Subject: **Request for Modification to Individual Section 404 and Section 401 Water Quality Certification** for the proposed construction of an extension of SR 1163 (Old Georgetown Rd) from SR 1184 (Ocean Isle Beach Rd) to NC 179 in Brunswick County, State Project 6.231023, TIP R-3432. Debit \$570.00 from WBS 35501.1.1

The purpose of this request is to modify the above referenced 404 Permit and 401 Water Quality Certification. Please see enclosed copies of the revised permit drawings and revised NCDMS acceptance letter for the above referenced project.

In order to prevent scour and undercutting the following revisions have been made:

PERMIT DRAWING
SHEET 3 OF 29

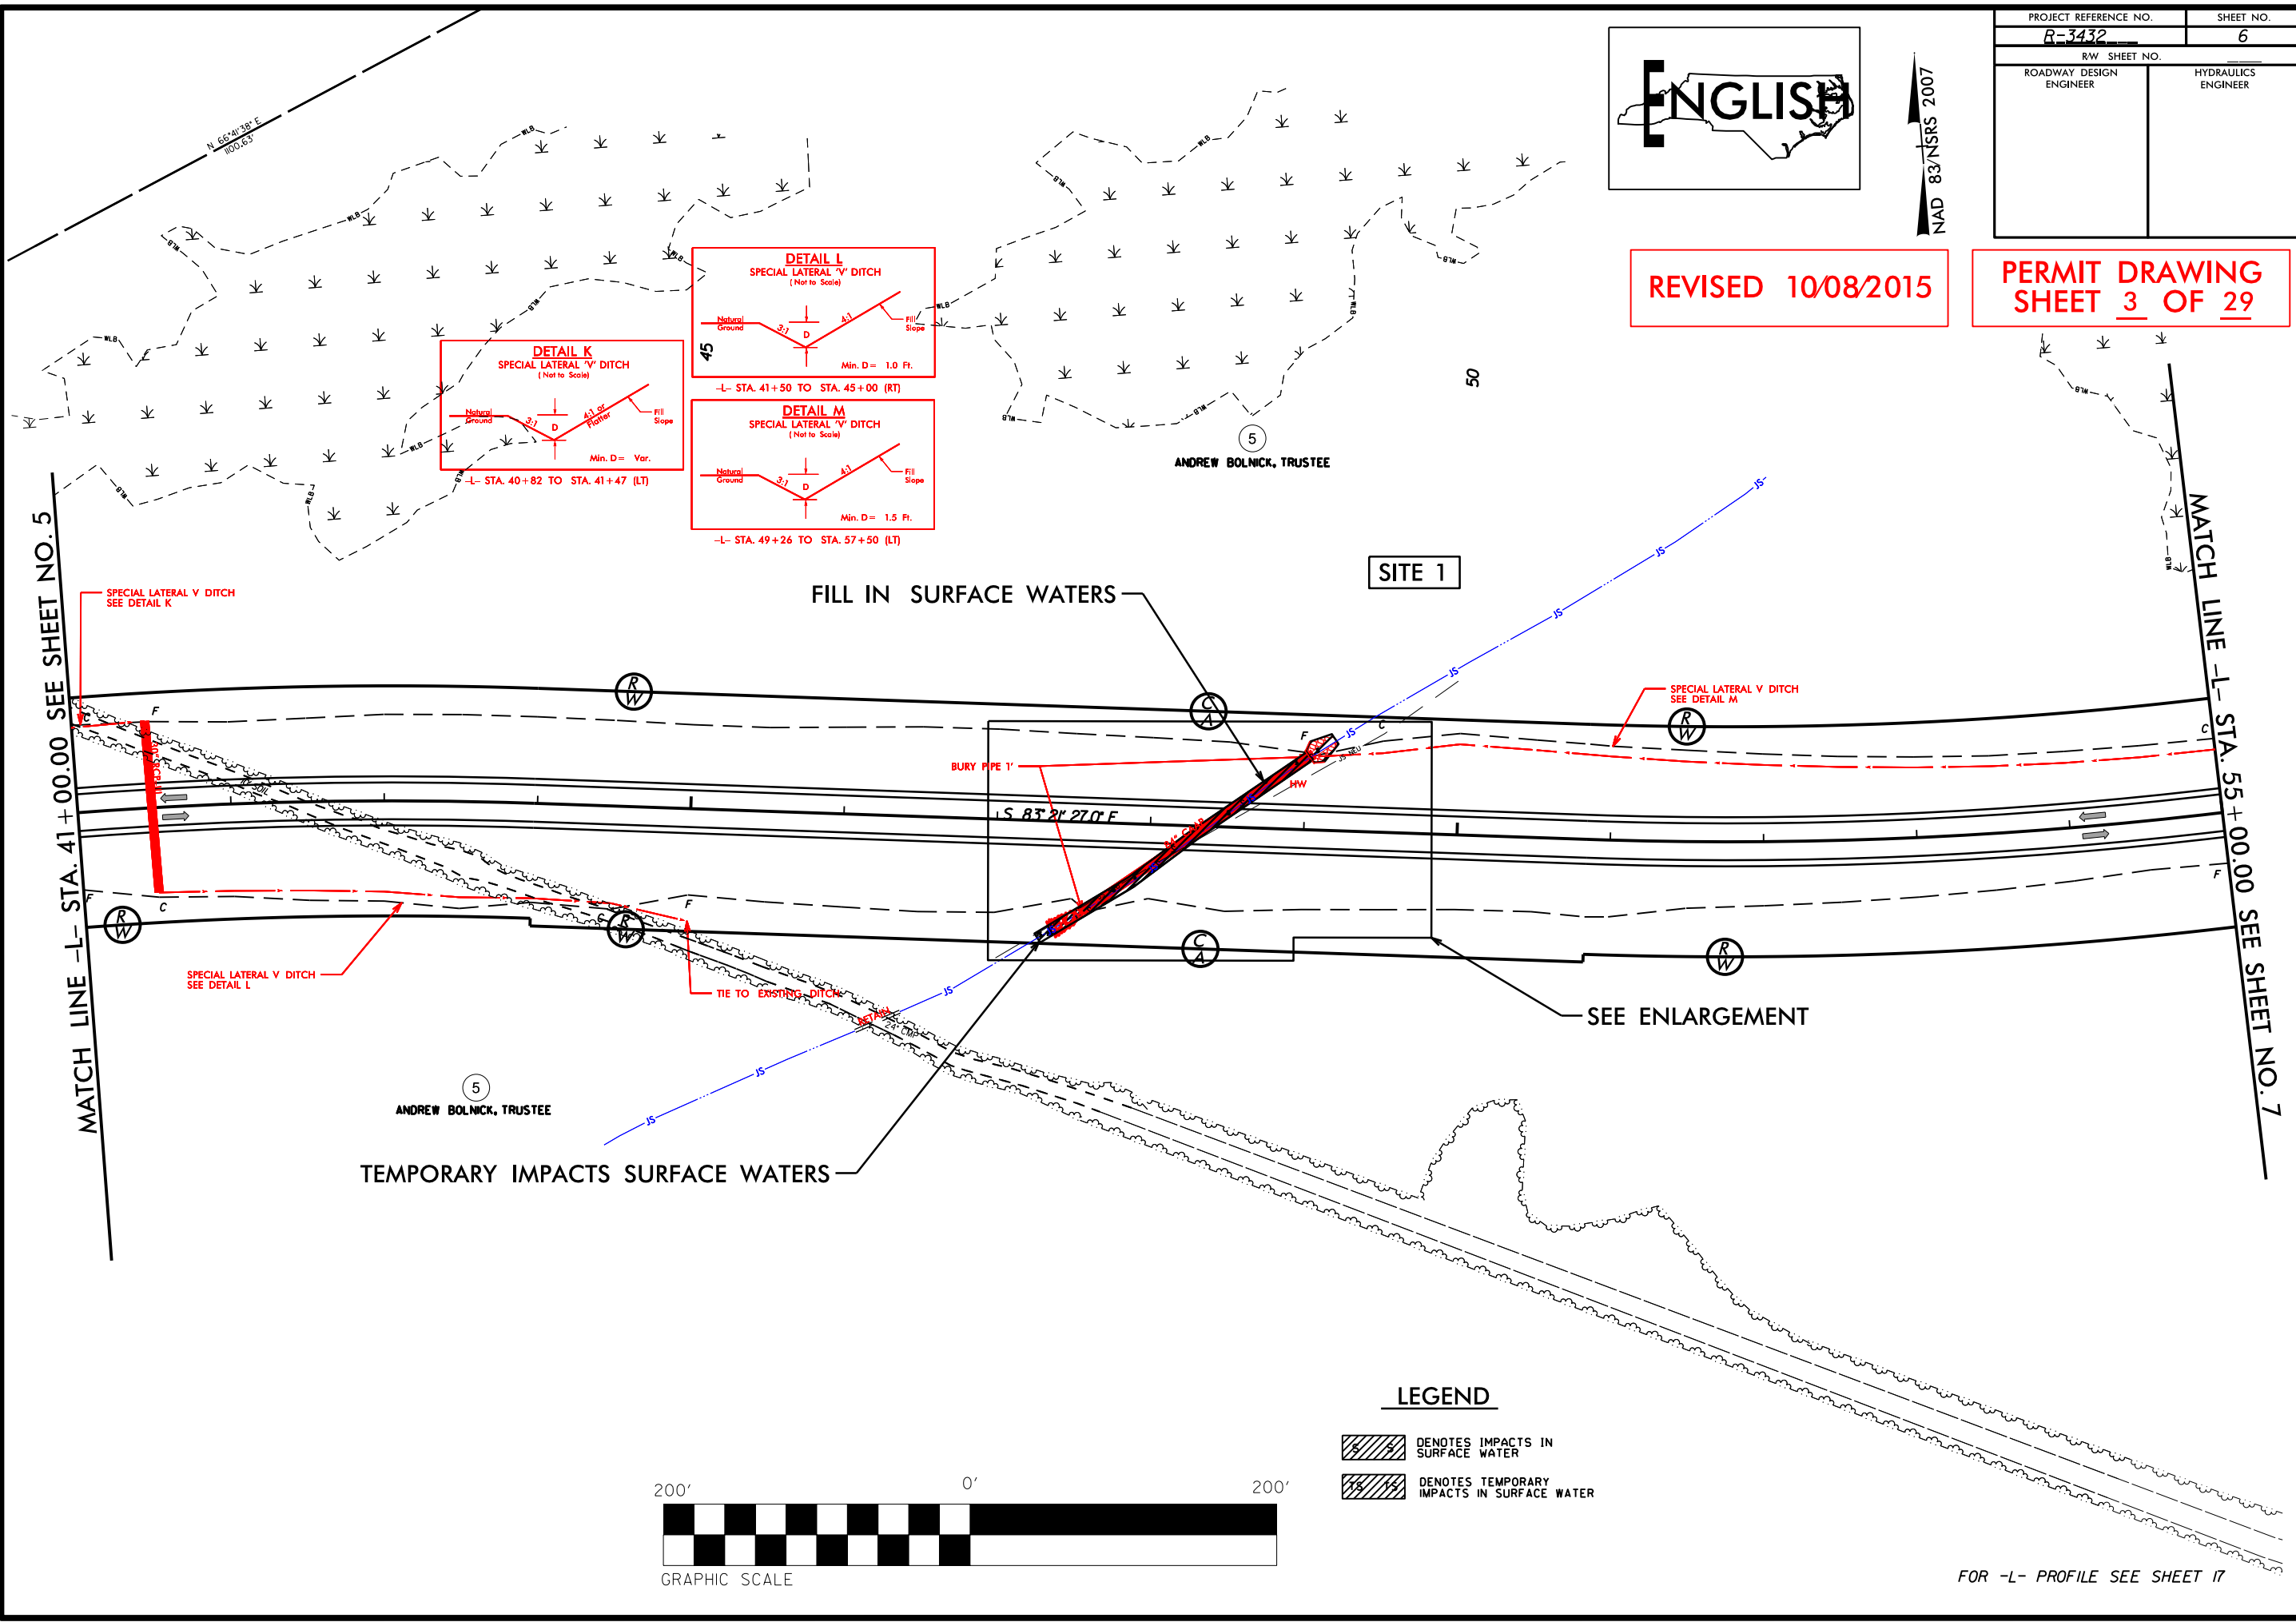
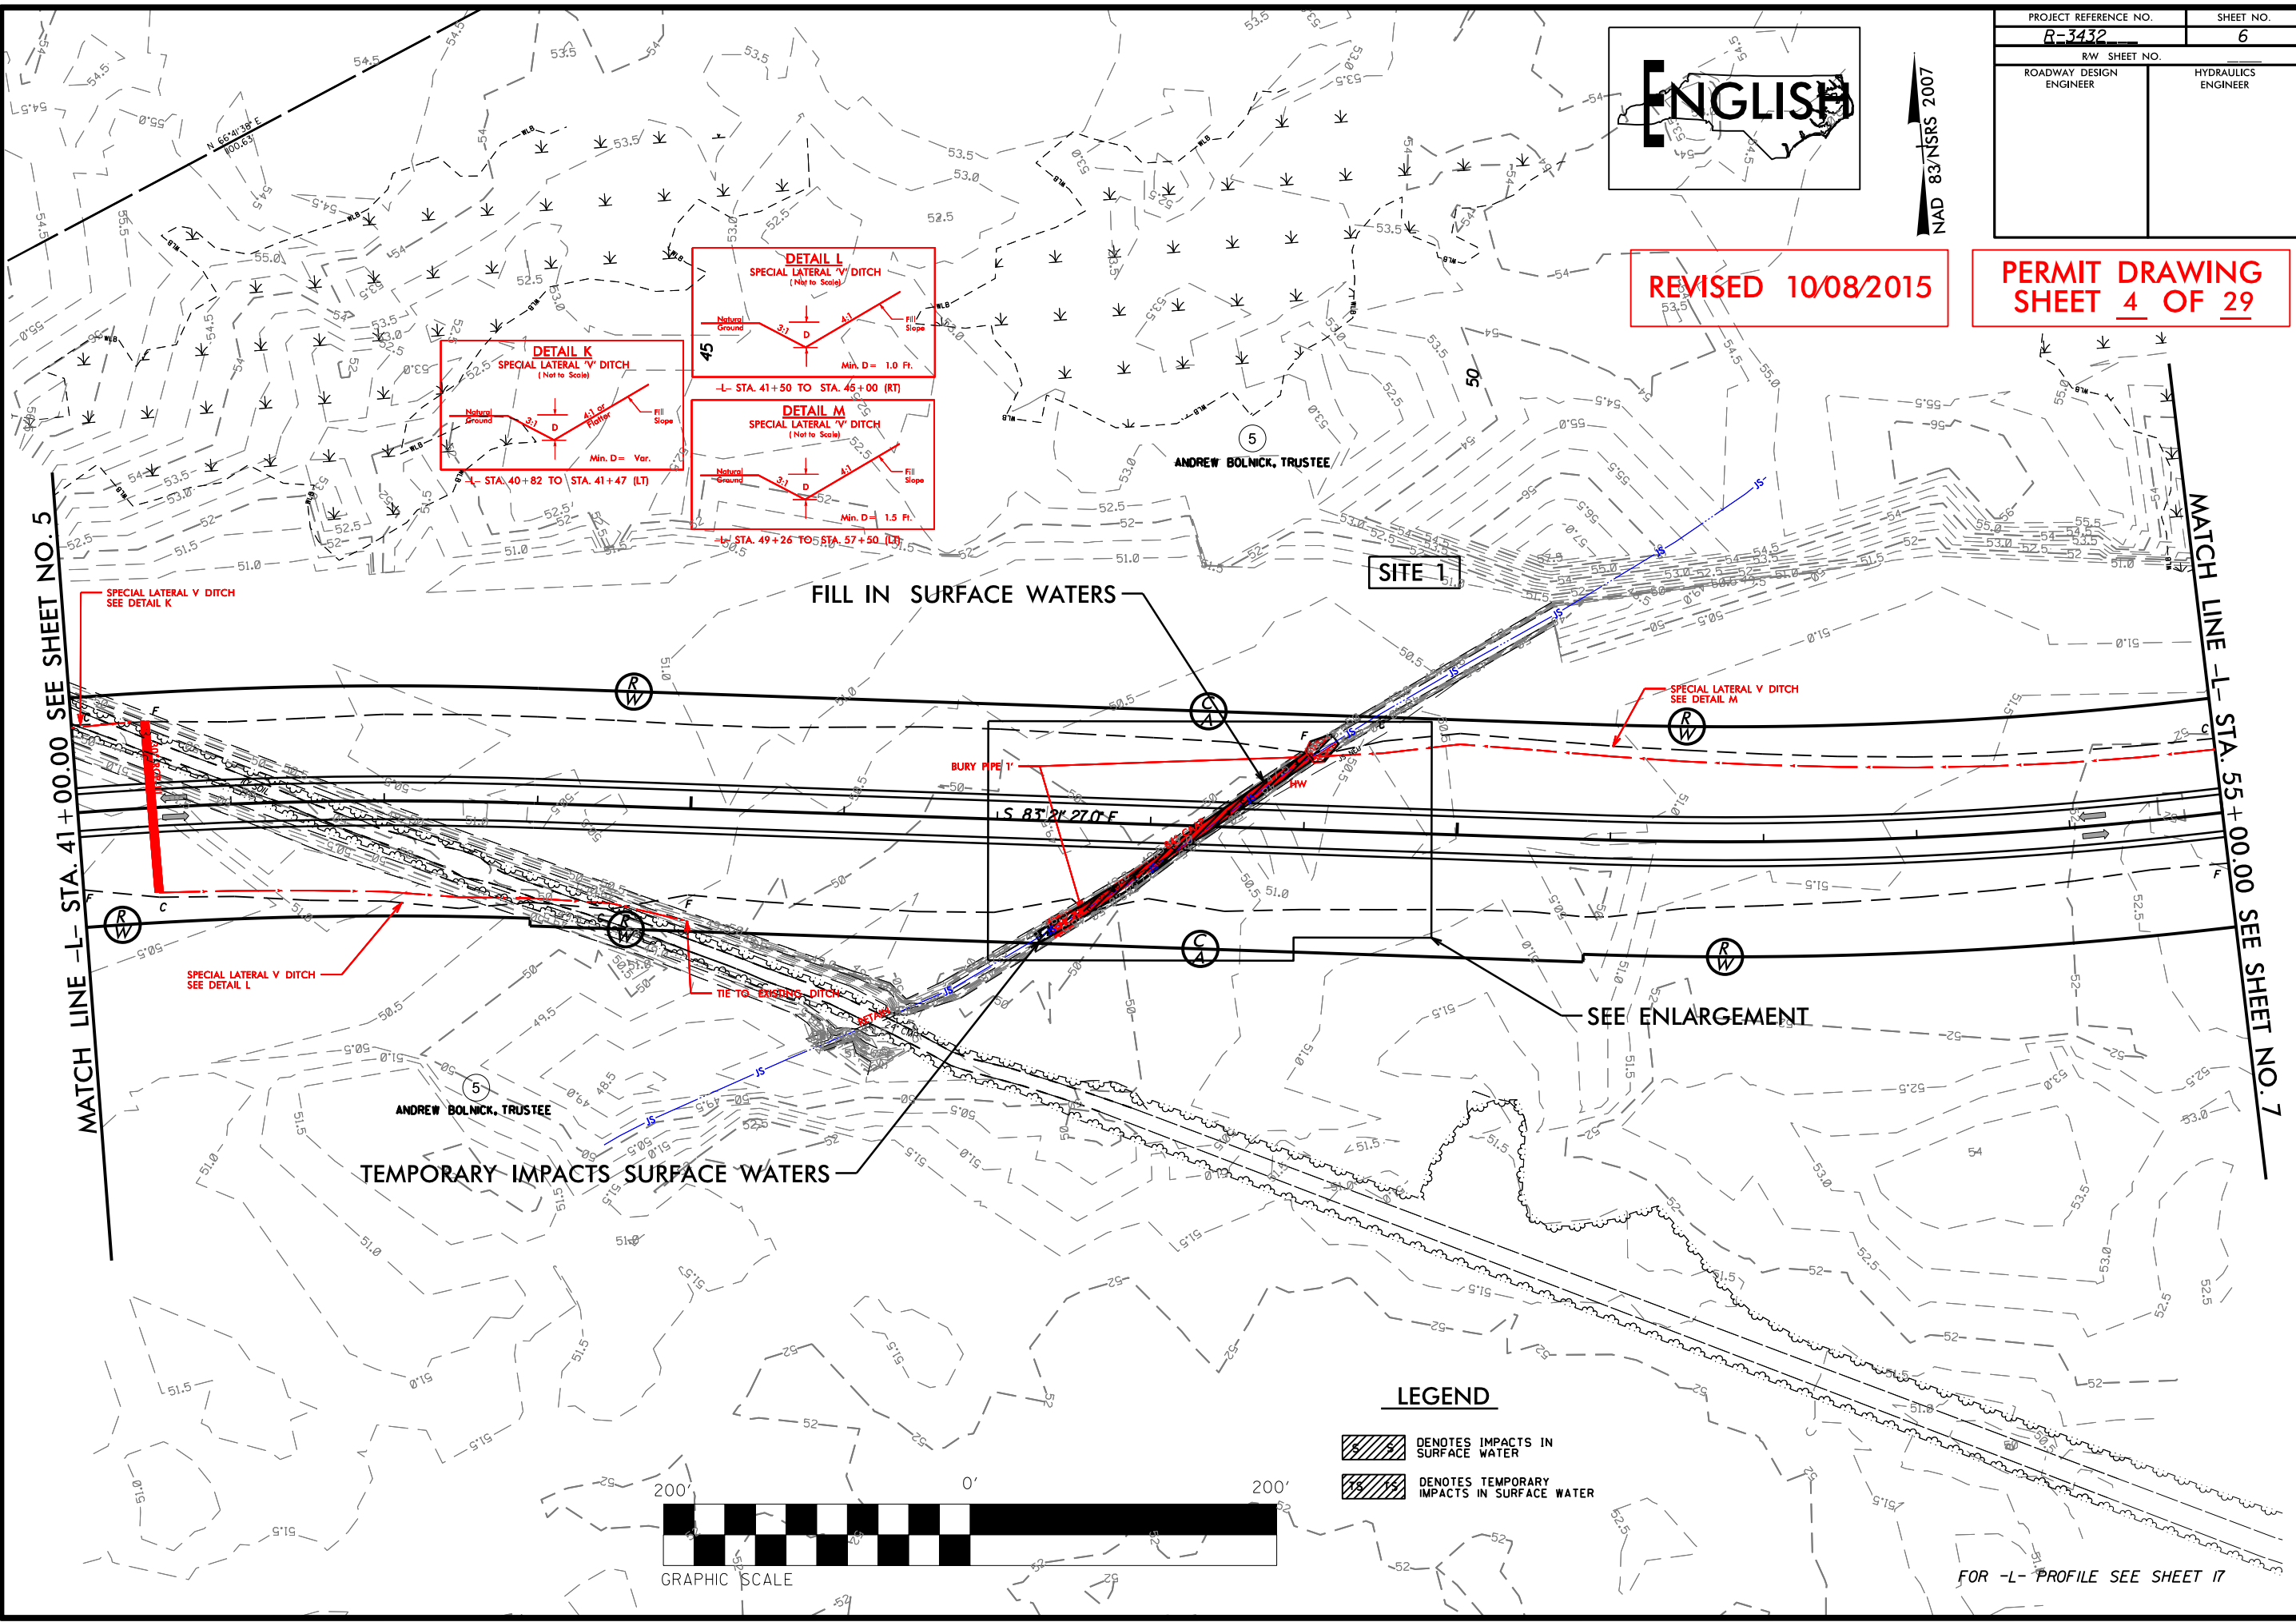
- Site 1. Additional riprap will be added at the inlet of the 84" CAAP. Surface water impacts will increase by 0.1 acre.
- Site 2. Additional riprap will be added at the outlet of the 30" RCP in prior permitted permanent impact areas. Mechanized clearing is increasing by 0.01 acre in prior permitted permanent impact areas.
- Site 3. Additional riprap will be added at the inlet of the 72" CAAP in prior permitted permanent impact areas. Mechanized clearing is increasing by 0.02 acre in prior permitted permanent impact areas with a decrease of 0.03 acre of excavation.
